**SUMMARY OF WRITTEN REPRESENTATIONS  
ON BEHALF OF THE  
HISTORIC BUILDINGS AND MONUMENTS COMMISSION FOR ENGLAND  
(HISTORIC ENGLAND)**

FOR AN ORDER GRANTING DEVELOPMENT CONSENT FOR THE: BOTLEY  
WEST SOLAR FARM**

**APPLICATION REF: EN010147**

**DEADLINE 2 SUBMISSION: 4<sup>TH</sup> JUNE 2025**

**Botley West Solar Farm  
Historic and Scheduled Sites Plan  
Sheet 7 of 24**

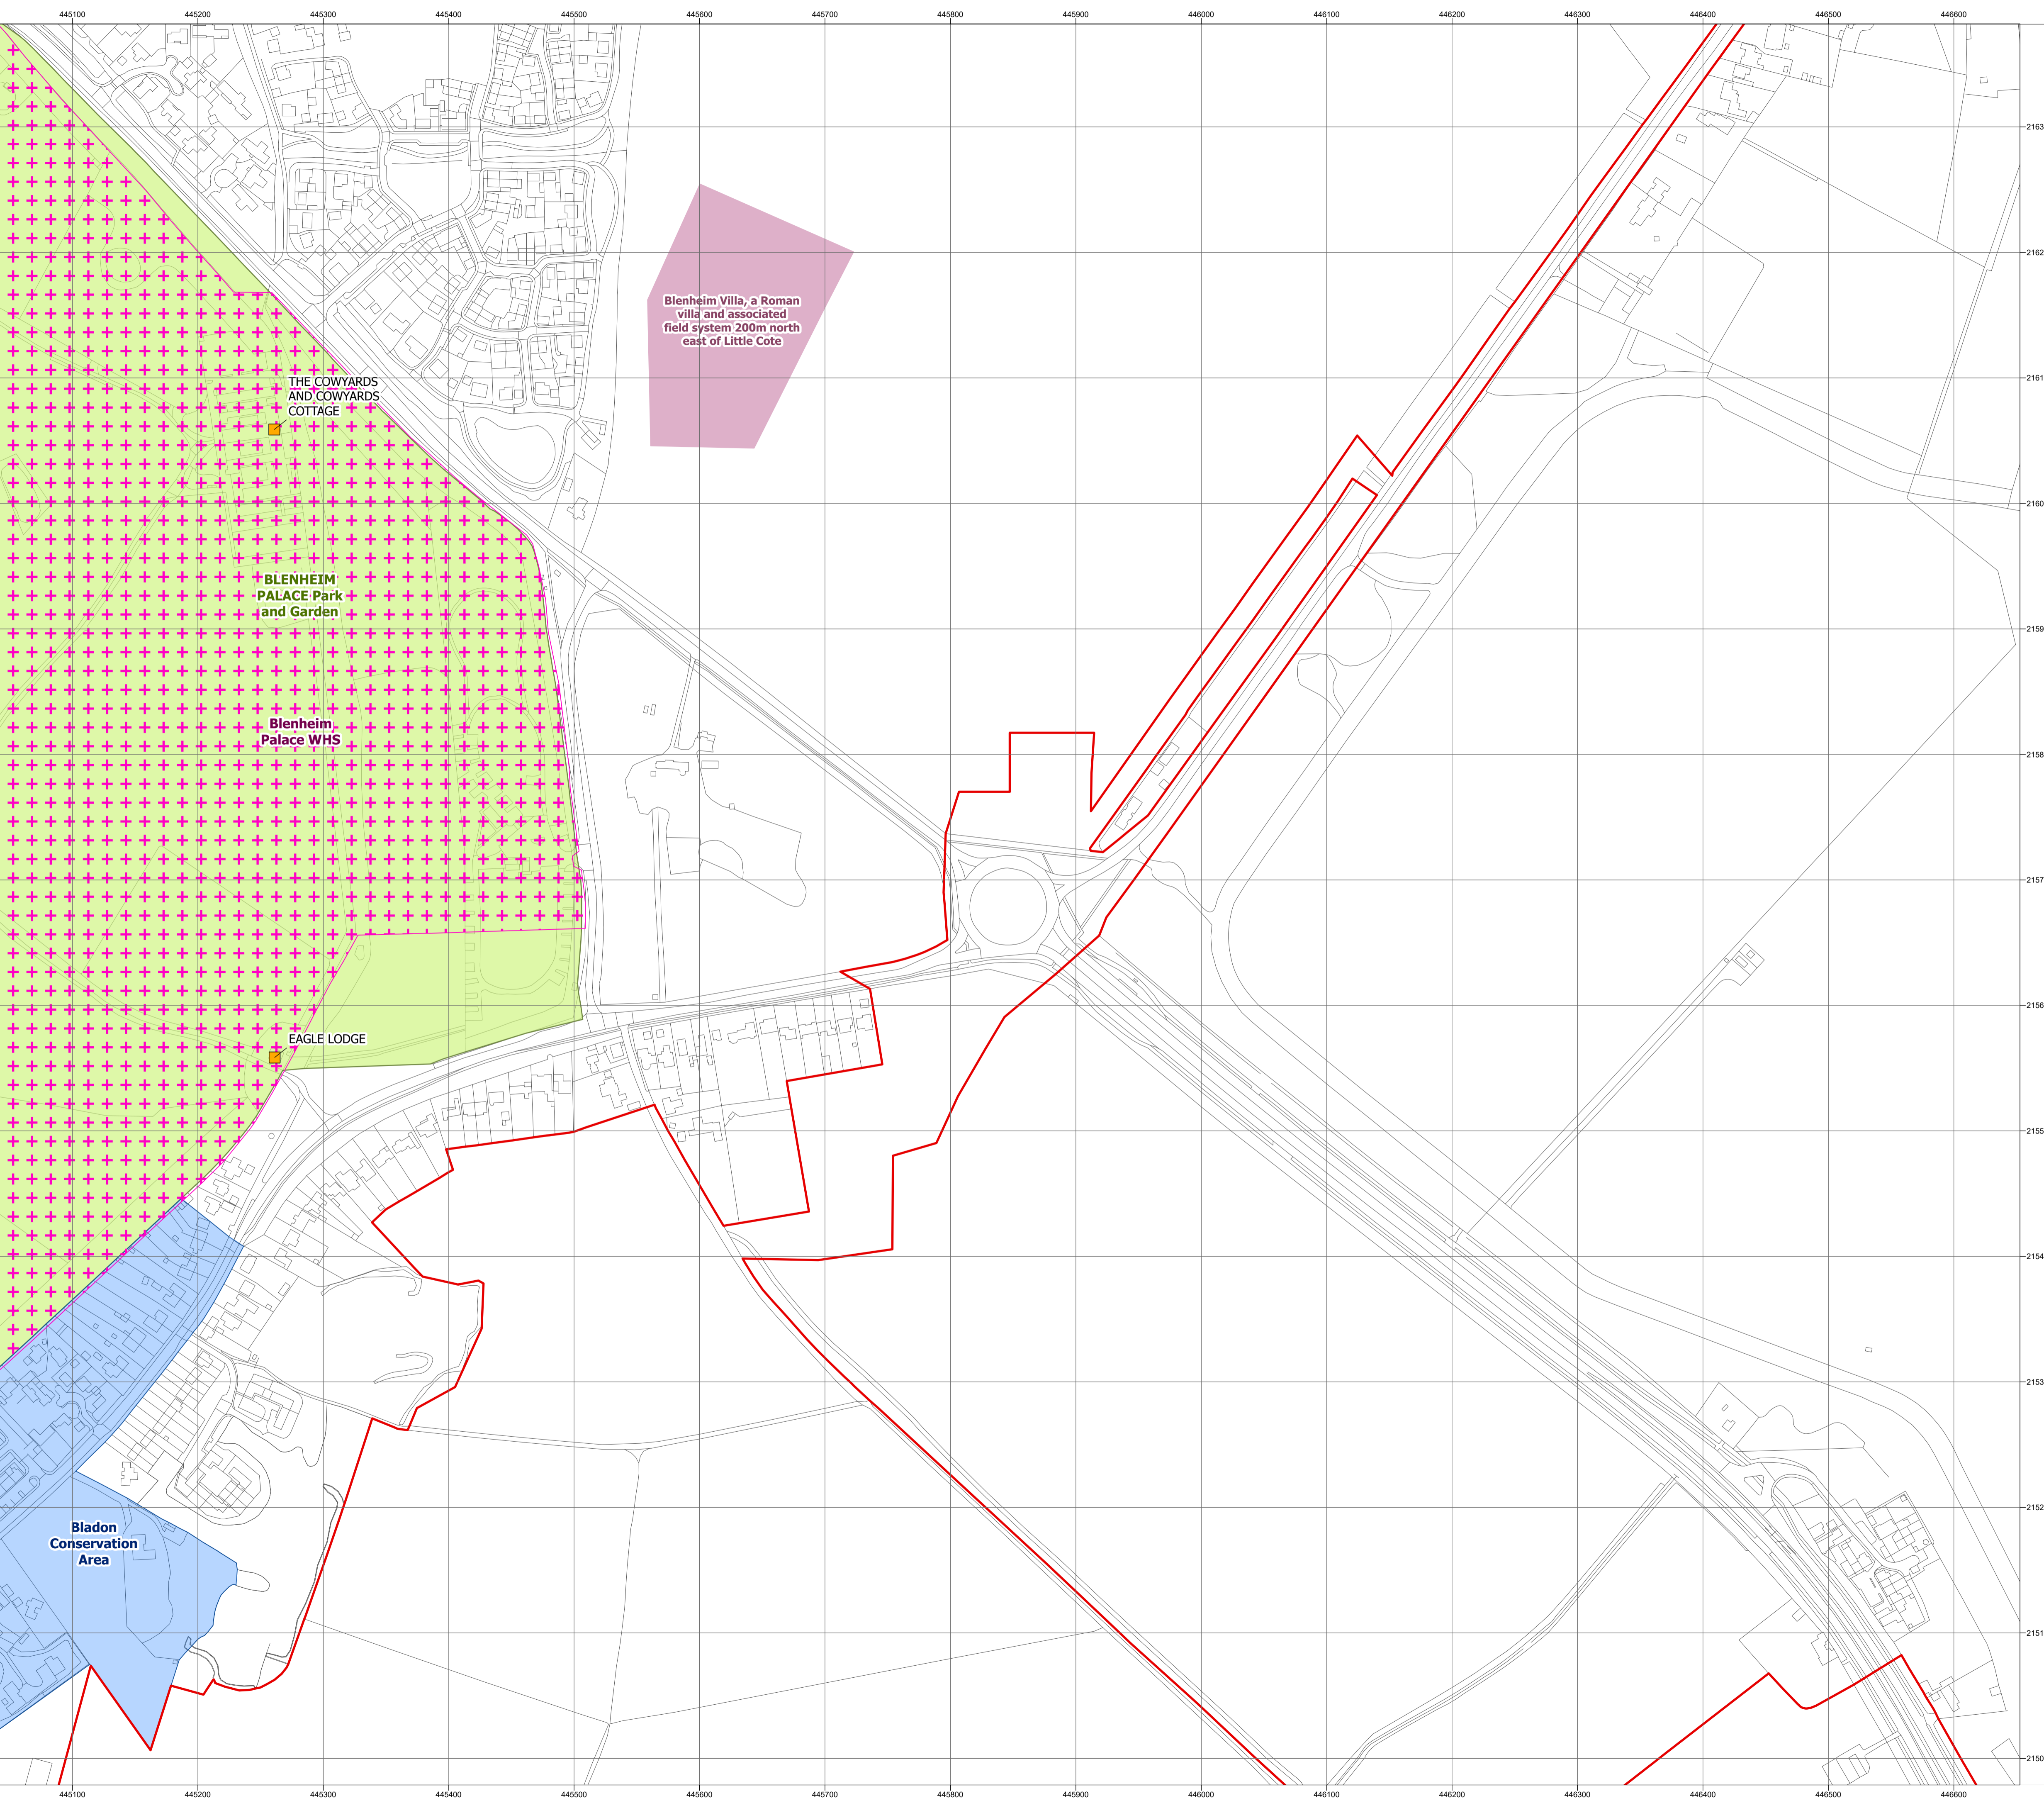
1.14 Based on the information available, and in the absence of the results of the trial trenching, the Roman Villa scheduled monument would be harmed through change in its setting. We consider that the Scheme's impact on the setting of the monument would be greater than the negligible concluded by the applicant. We recommend the applicant revisits these conclusions to ensure the impacts are identified at the appropriate level.

**Botley West Solar Farm**  
 Historic and Scheduled Sites Plan  
 Sheet 8 of 24

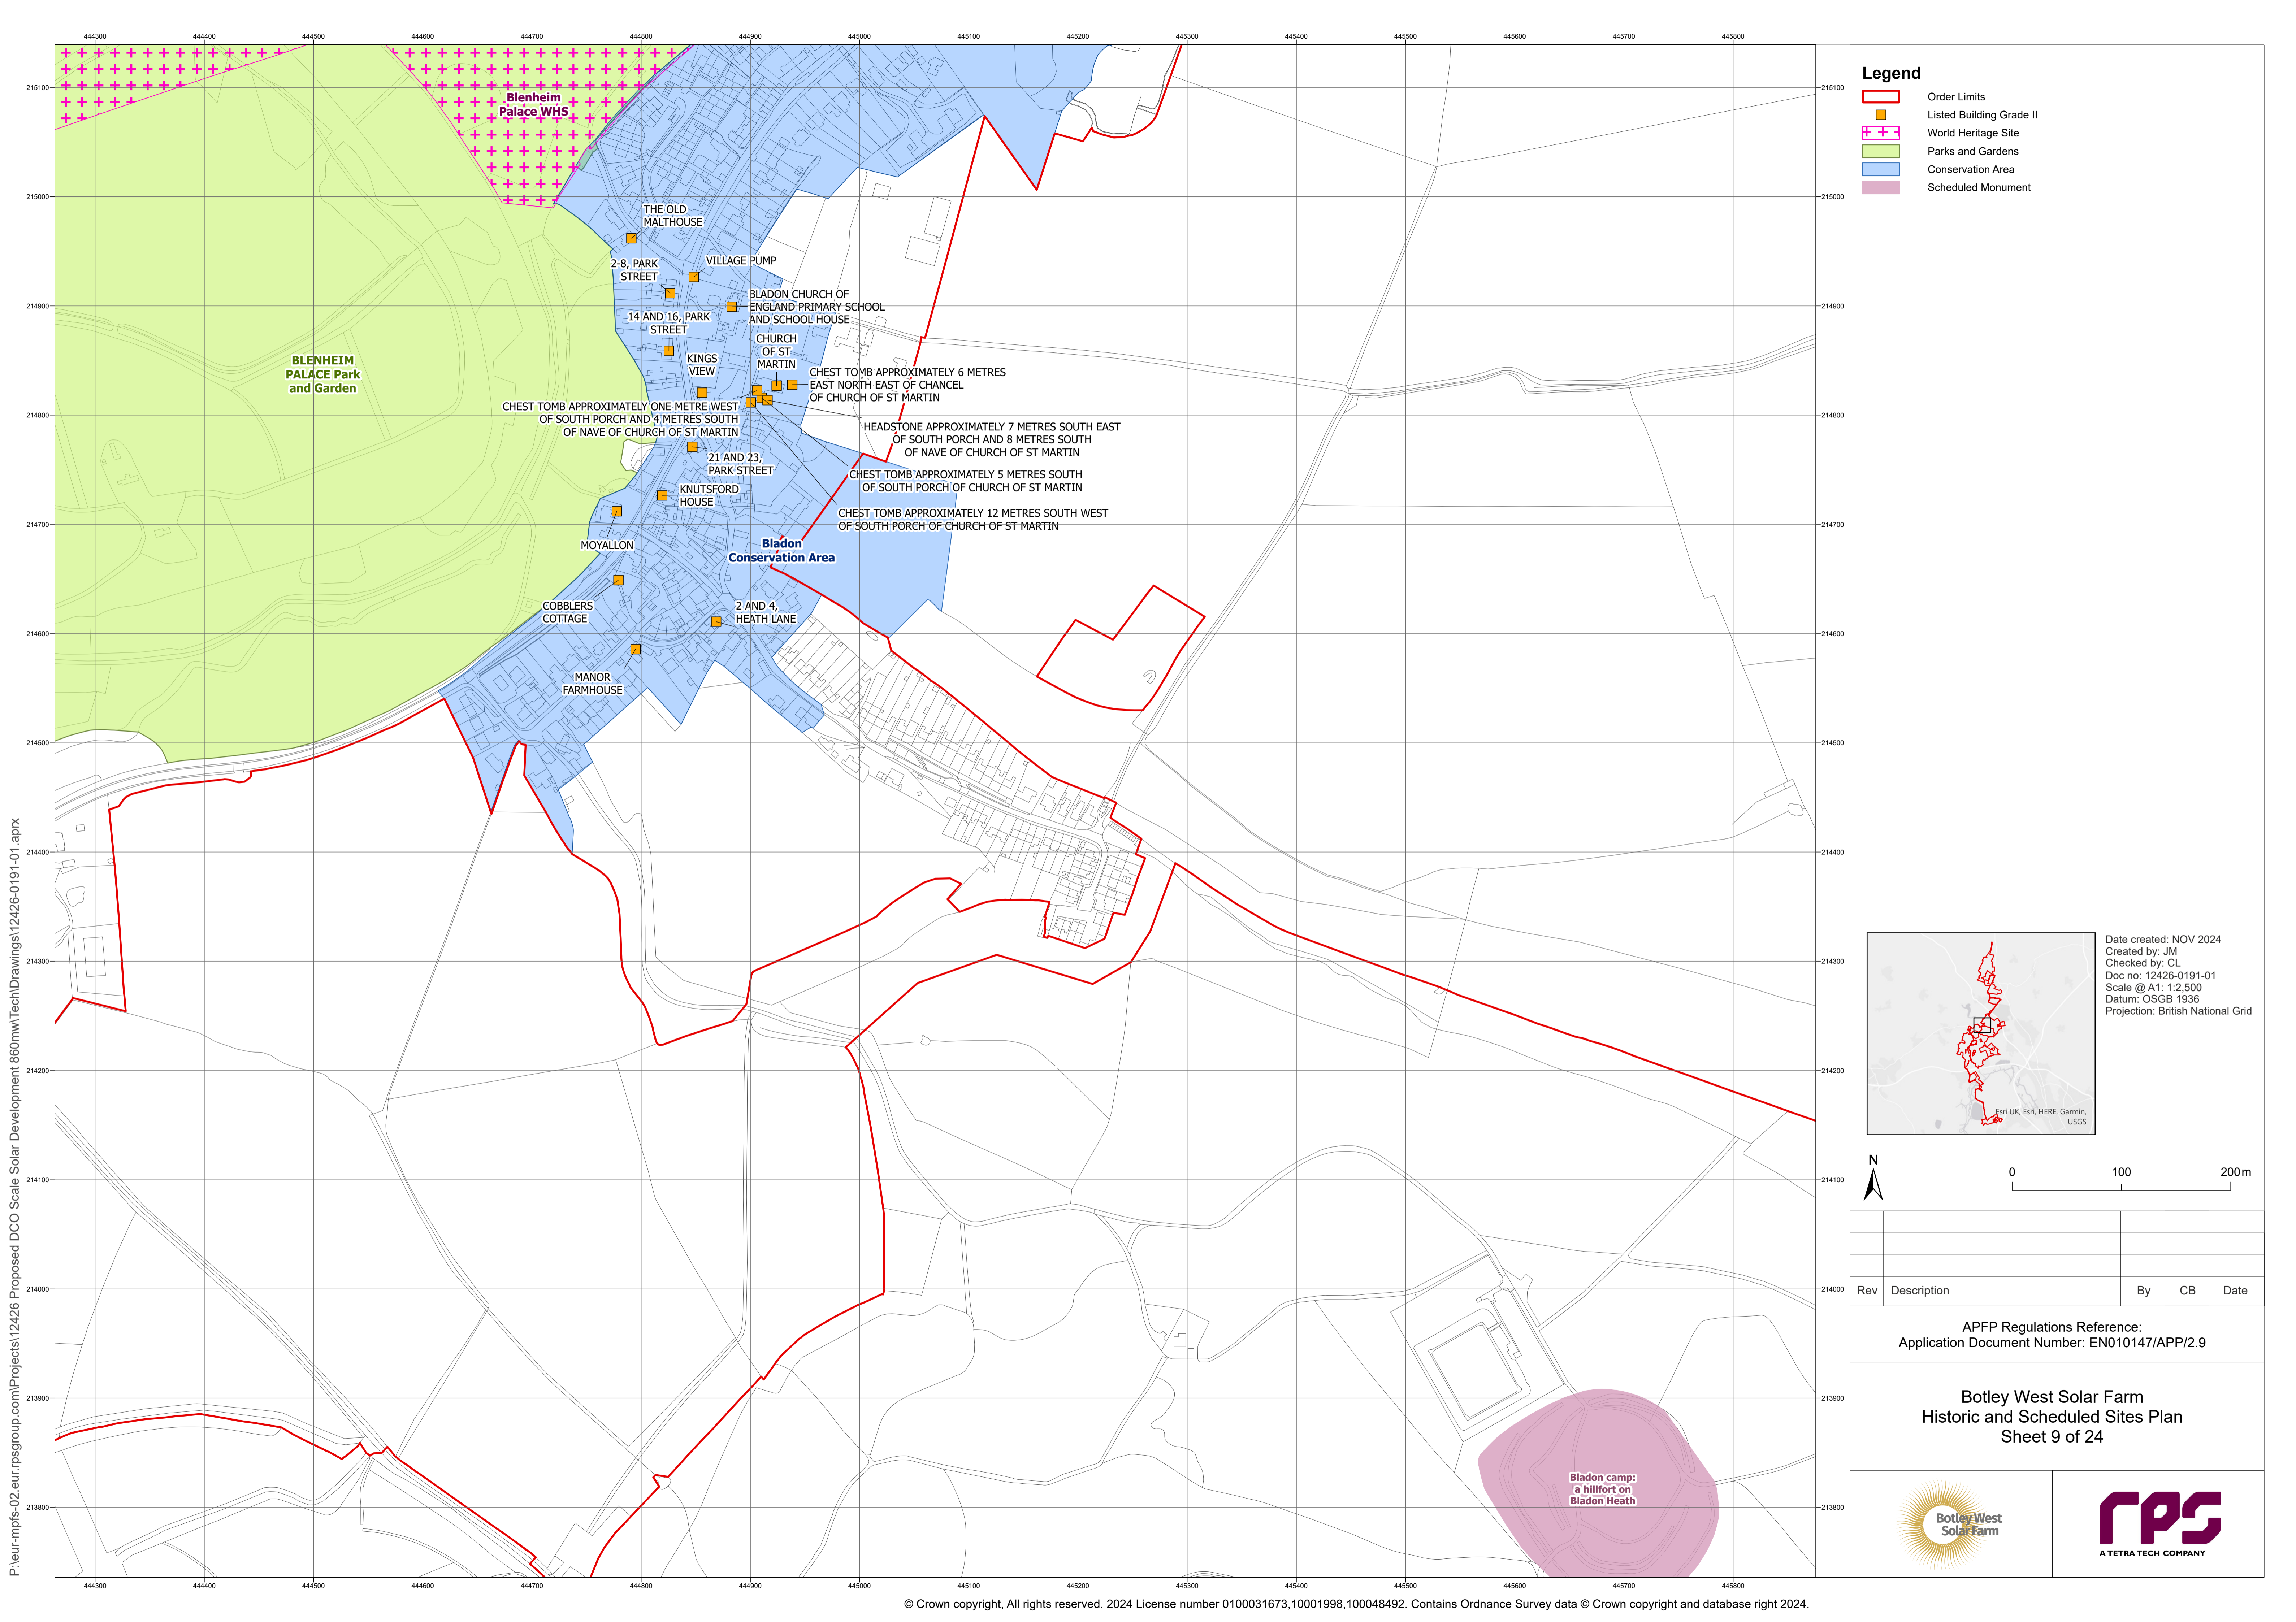
1.13 We consider that the harm to the Blenheim WHS, palace and RPG could be avoided through targeted changes to the scheme, by removing the solar panels from the fields immediately to the south of Bladon. In our assessment, the fields within the application site, which contribute to the setting and OUV of the WHS are fields marked 2.1, 2.2, 2.5, and 2.20-2.26 in Figure 2b within ES Appendix 7.1: Historic Environment Desk-based Assessment (EN010147/APP/6.5).

- 1.17 We recommend in future visits to the Site, the ExA walks the Public Rights of Ways through the agricultural fields (part of the application site) to the south and southwest of Bladon. We recommend the ExA observes the visual connection and contribution these fields make as part of the setting of the WHS, Blenheim Palace, Blenheim RPG, and the churches of St Peter and St Paul, Church Hanborough, St Peter's, Cassington and St Michael's in Begbroke. In the northern section of the application site, we recommend the ExA visit the scheduled monument of Sansom's Platt to assess the impact upon it through the proposed change of setting.
- 1.18 We recommend consideration is given to including a provision within Schedule 16 of the DCO for the Local Planning Authority to consult with third parties.
